Re: Ottawa Community Housing 200 Beausoleil Drive

Ottawa Community Housing, with our architects, have responded to City Planning comments that were provided to OCH on XXX YY, 2023 regarding our application for 200 Beausoleil Drive.

Figure 11: Proposed Landscape Plan (Source: Diamond Schmitt Architects)

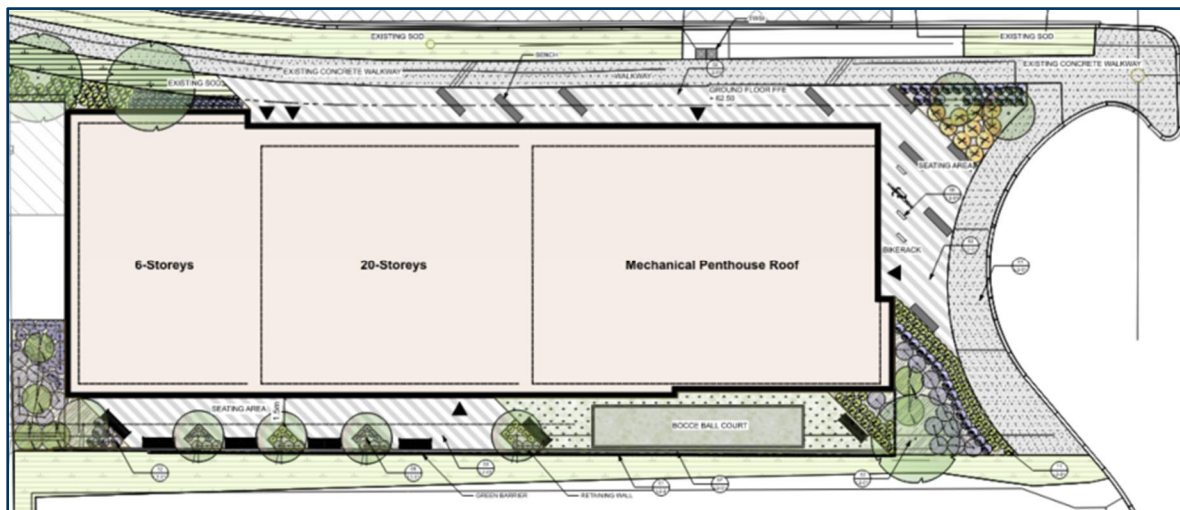
Comment 1.18: "Staff would like to see the sidewalk along Beausoleil directly adjacent to the site improved to a 2-metre width ideally. Please clarify what impediment exists to provide this as part of site development".

We would point out that this and other buildings in design do not, and may not have grant funding attached to them, requiring OCH to wholly fund construction. Adding additional City infrastructure requirements to our project would place greater hardship on the corporation, and would require higher rents to be charged, as the rents need to support the operations, maintenance, and mortgage costs. We would respectfully ask that this consideration not be placed on OCH.

We would, however, work closely with the City to facilitate any of it's work, whether through coordination of work or integration into our project, with the City assuming the additional scope requirements.
